6665 Walker Road Minor Subdivision Transportation Memorandum

(LSC #S214800)
January 11, 2022

LSC Responses to Traffic Memo Comments

Figure 2
Site Plan

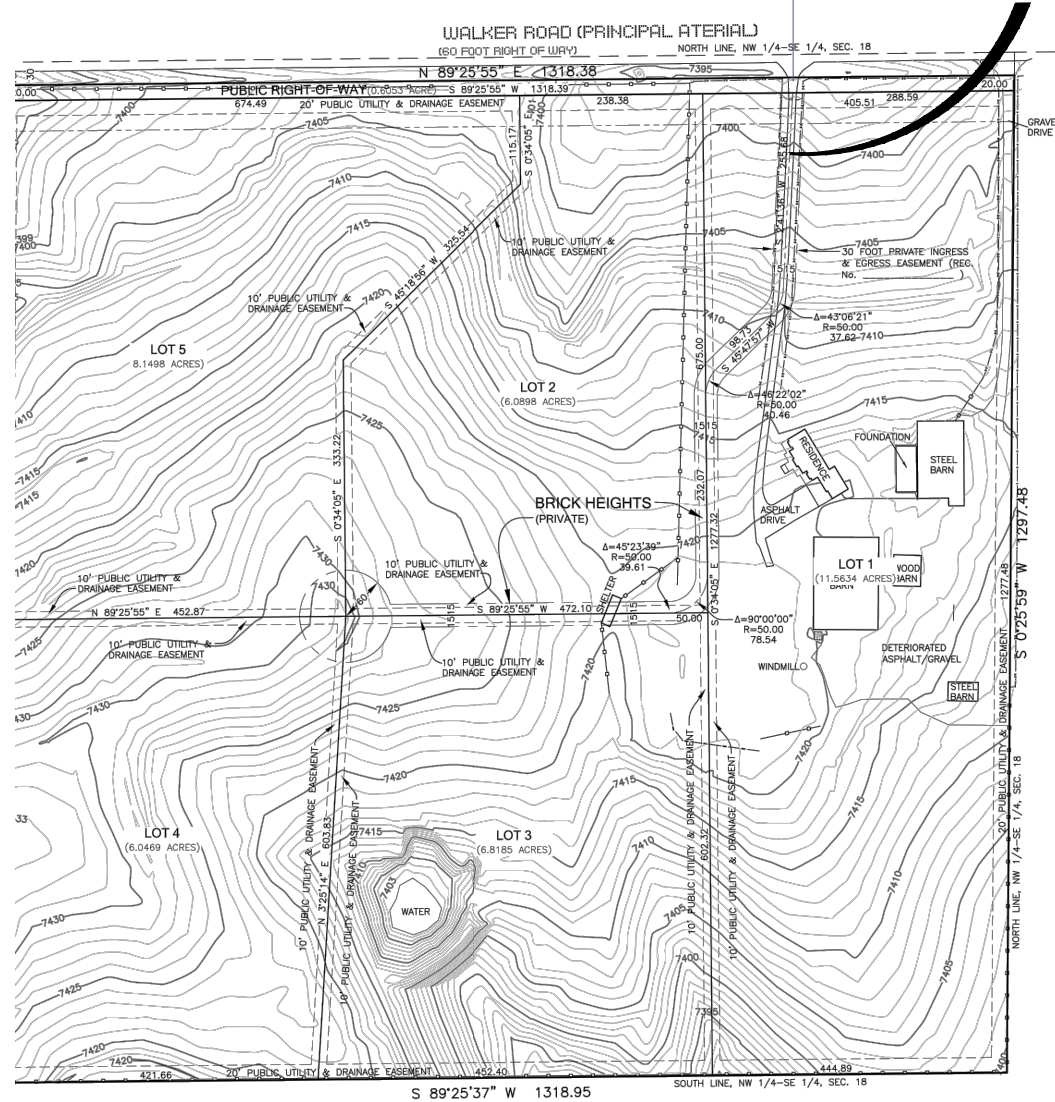
The preliminary plan shows a different layout. Revise to match or coordinate with other engineer to consistent with the other plan.

LSC Response: The traffic memo has been revised to match the current preliminary plan.
